Prevent • Promote • Protect

Fall Mountain Farm, PPR-22-46

Please accept the following comments from El Paso County Public Health for the request referenced above:

Mike McCarthy
El Paso County Public Health
719-332-5771
mikemccarthy@elpasoco.com
03October2022

SHEET TITLE: **SITE DEVELOPMENT PLAN**

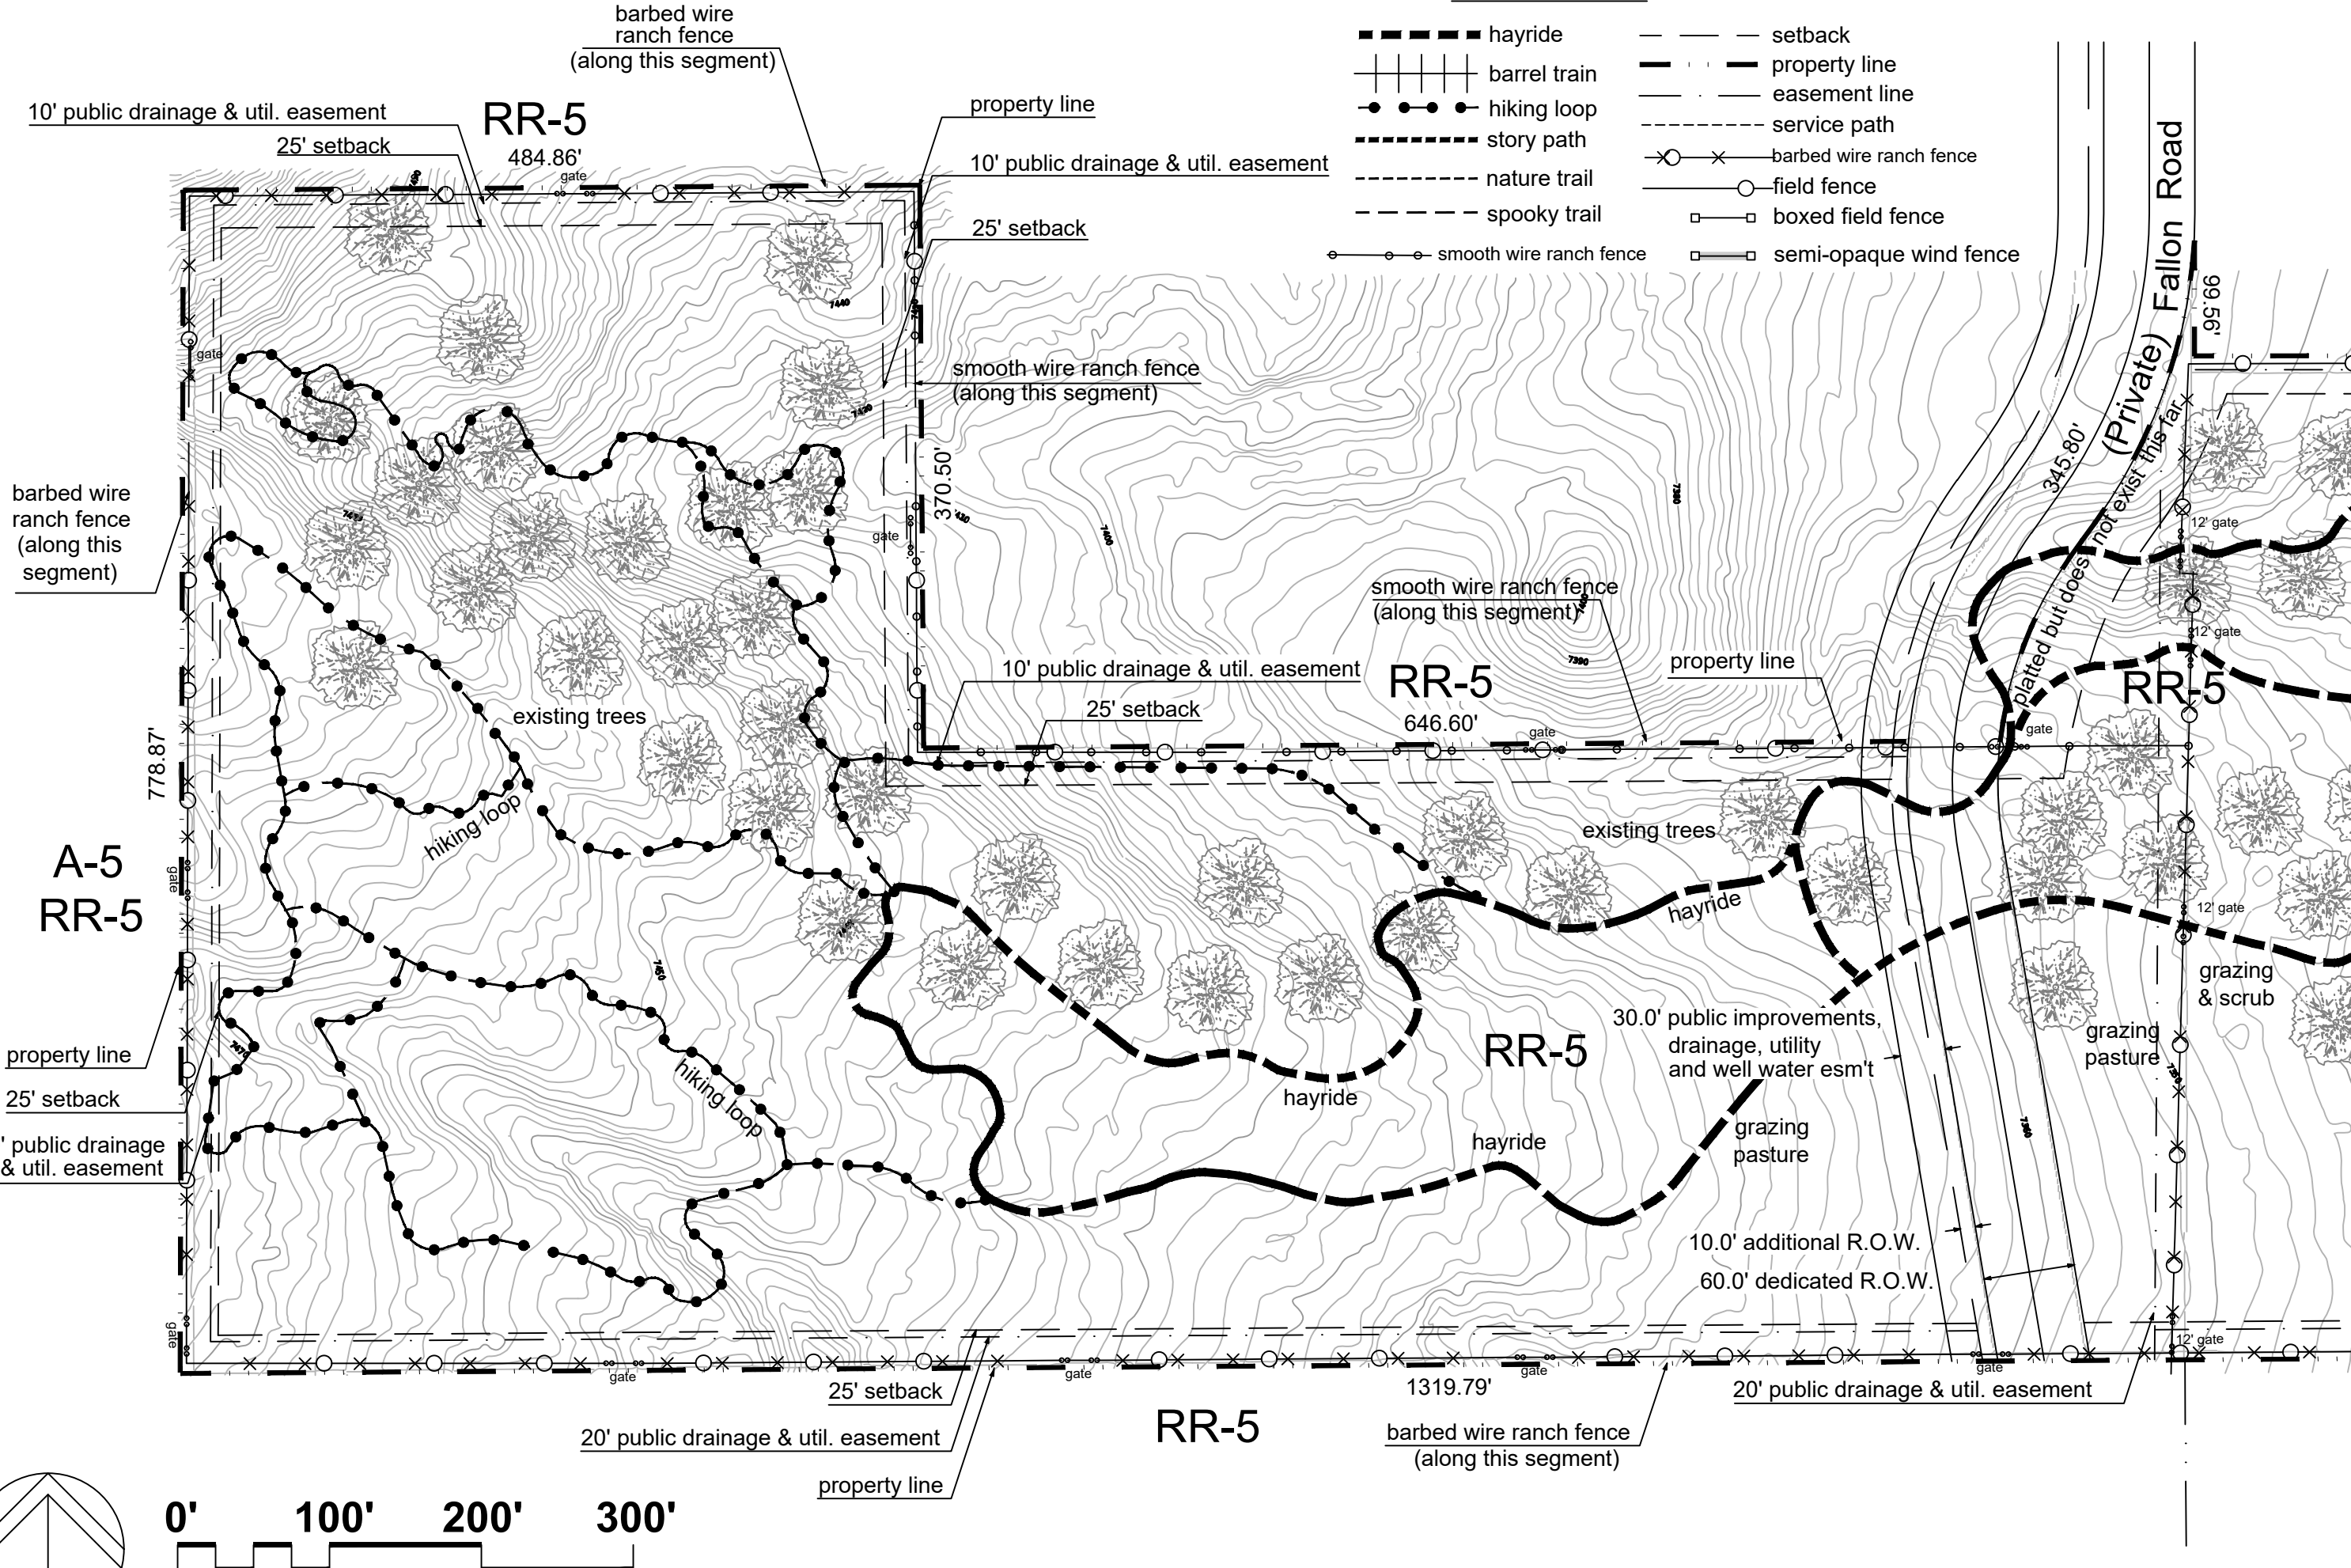
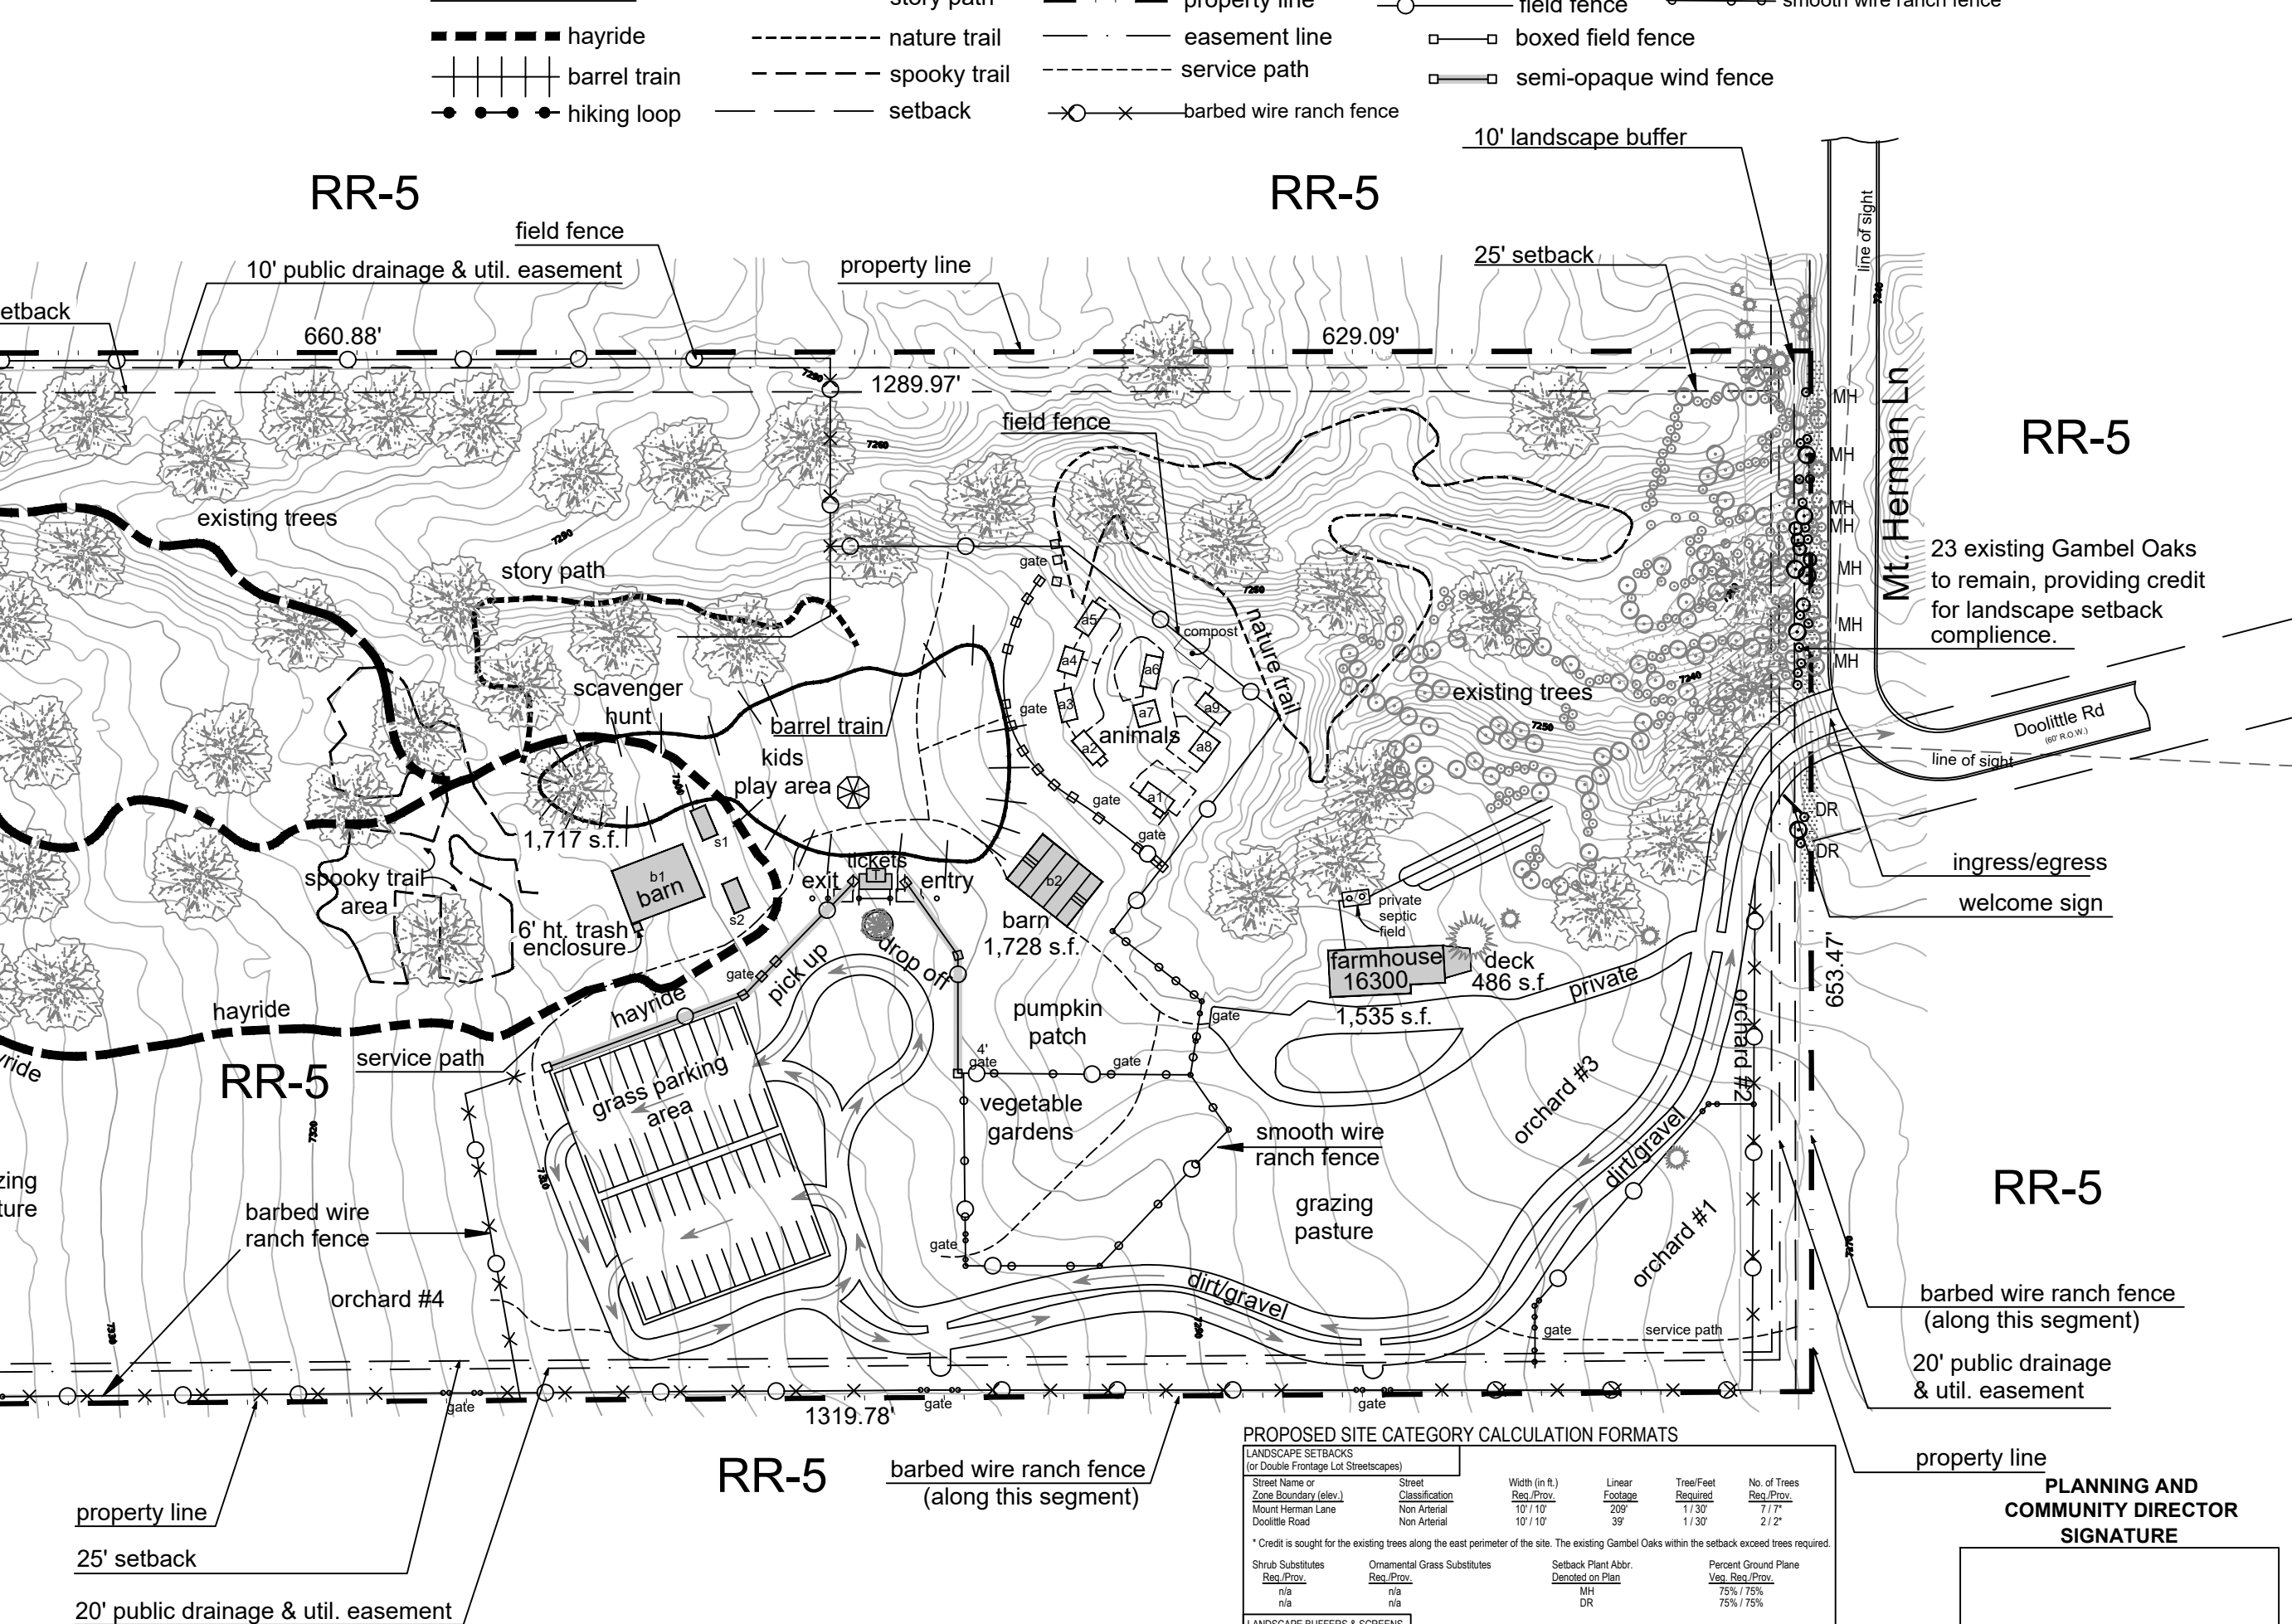
- Animal waste must be collected and removed as needed to minimize odors, and insect/rodent attraction.
- The existing residence is connected to an onsite wastewater treatment system (OWTS) installed and approved in 1987 for a 4-bedroom house. Please locate the OWTS soil treatment area to make sure traffic and parking will not be in the proximity to the soil treatment area.
